Application for a non-material amendment following a grant of planning permission. Town and Country Planning Act 1990

| Street address: | <input type="text" value="E Entrance to Car Park From Comet Way"/> | | |

Planning approval has been given for the erection of a public house on the application site.

Drawing Title:
Landscaping and Acoustic Fence

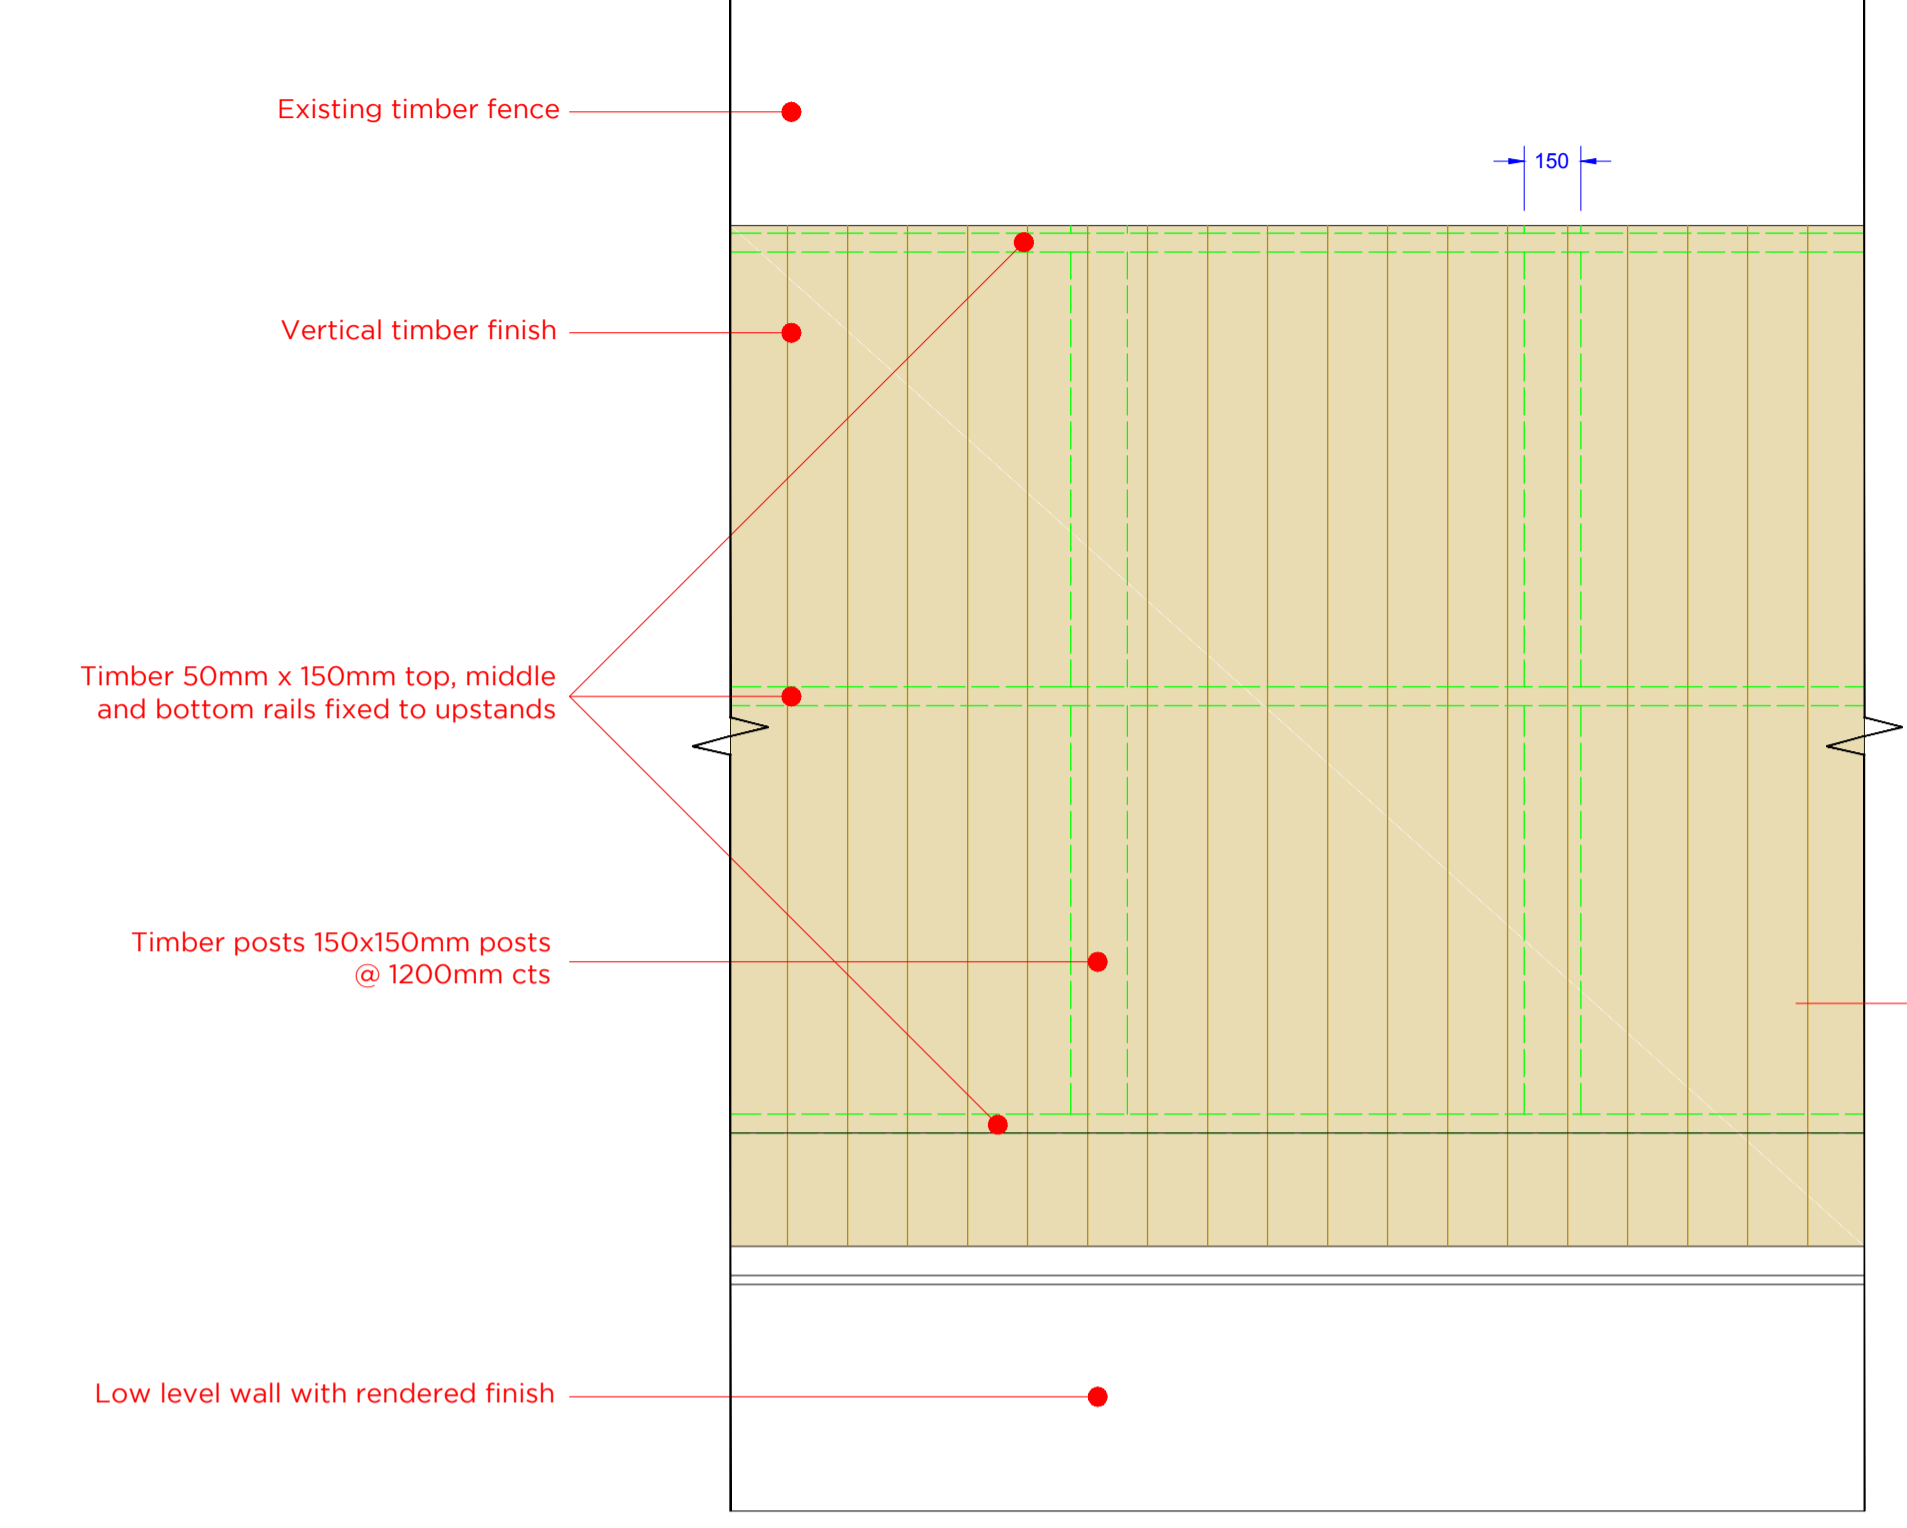
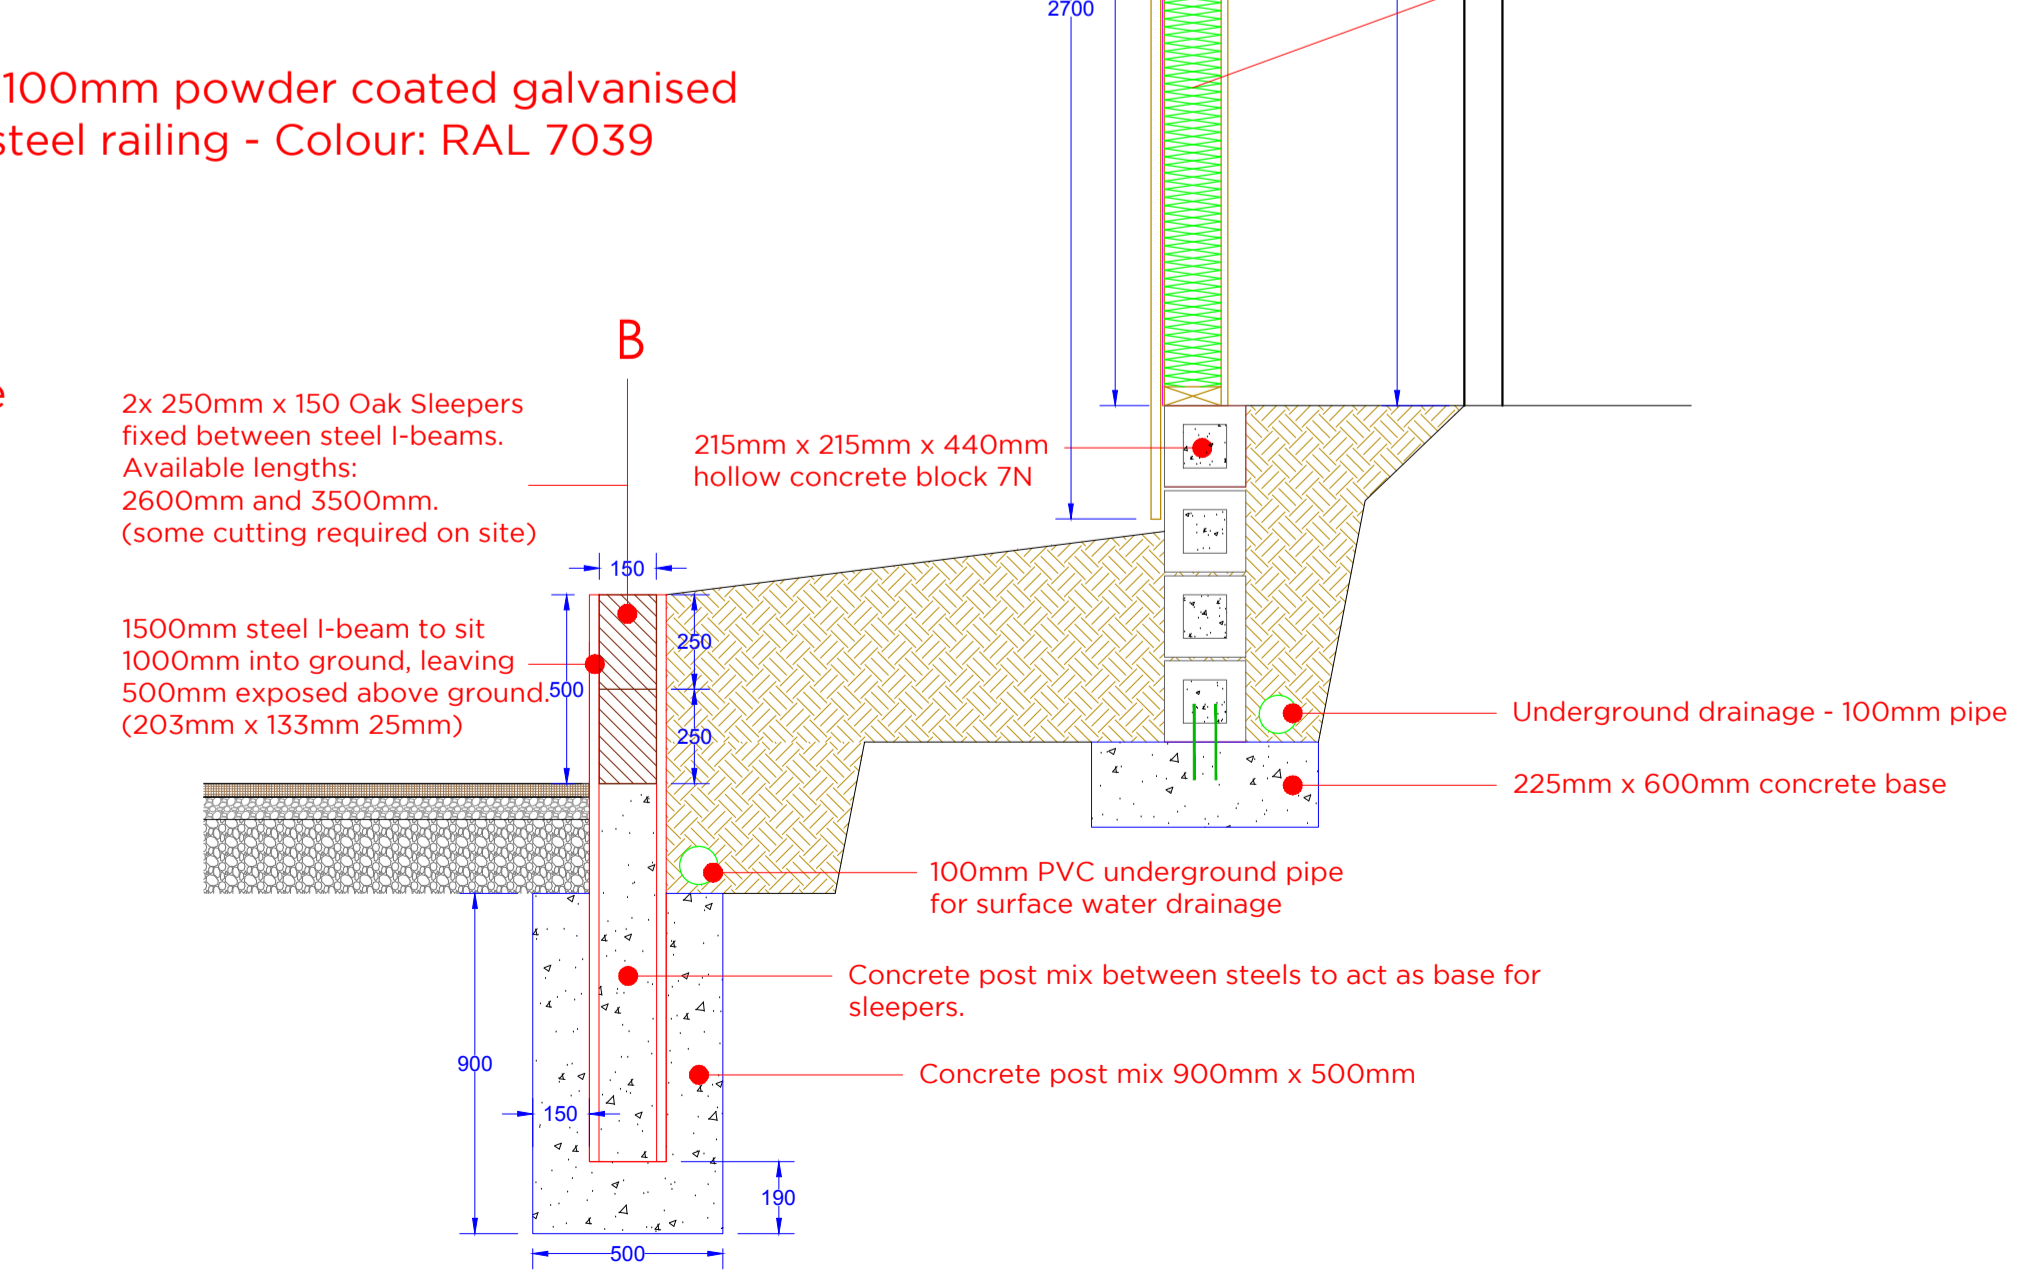
- Various landscaping alterations to include Raj, Indian stone flags, sleeper style walls, tree specification and locations, acoustic wall added, refuse store changed, drop kerbs added, herringbone pattern granite paving to rear.
